**Our ref:** 25\_30828\_P

**Site Location:** Land off Broadgate Weston Hills  
Spalding

**Summary of Proposal:** Rural exception site  
of 24 affordable homes

622.SL.01

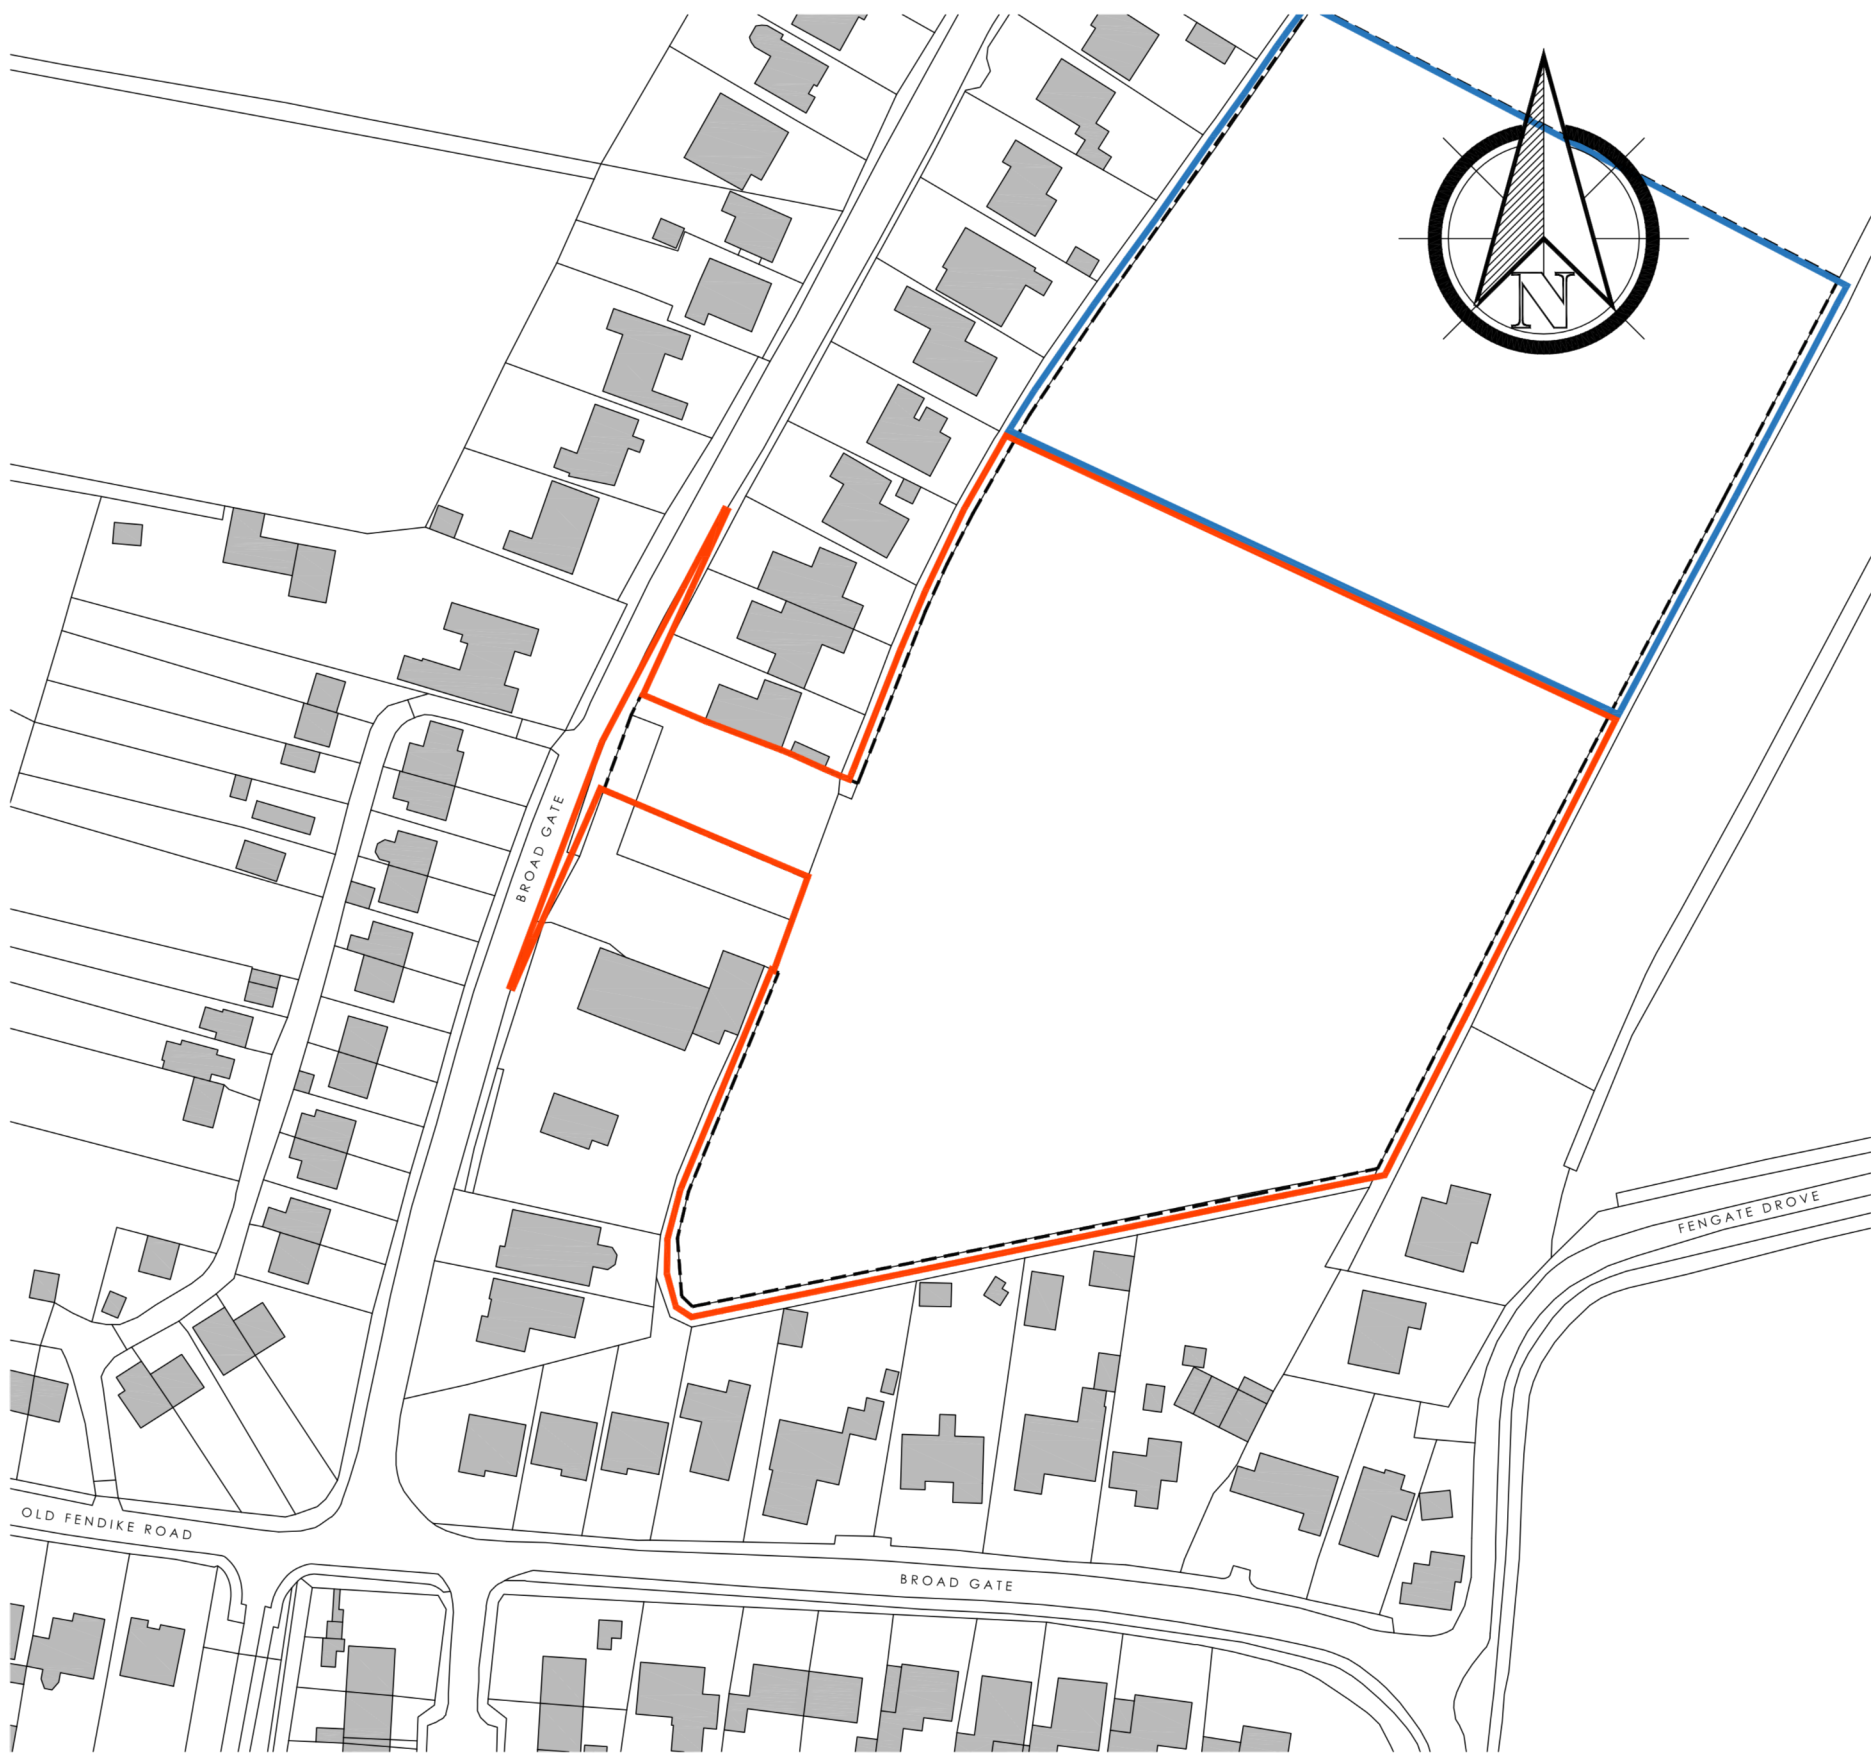
- 3) Lastly, the Board are deeply concerned that no regard to future maintenance of the riparian watercourse has been taken into account when designing the layout for this proposal. The proposed layout does not currently provide a maintenance strip adjacent to the watercourse and will result in the fences of 18 private gardens being installed up to the brink of the watercourse. This will lead to the watercourse having multiple riparian owners under riparian law with no suitable access to carry out their maintenance responsibilities which is likely to lead to flooding issues within the wider site and surrounding area. **The Board therefore object to this planning application** and recommends that the applicant redesigns the layout so that a suitable maintenance strip (around 3-5 metres) is left flat and free from obstruction adjacent to the riparian watercourse in order to enable maintenance by one future riparian owner/designated maintenance company/contractor.
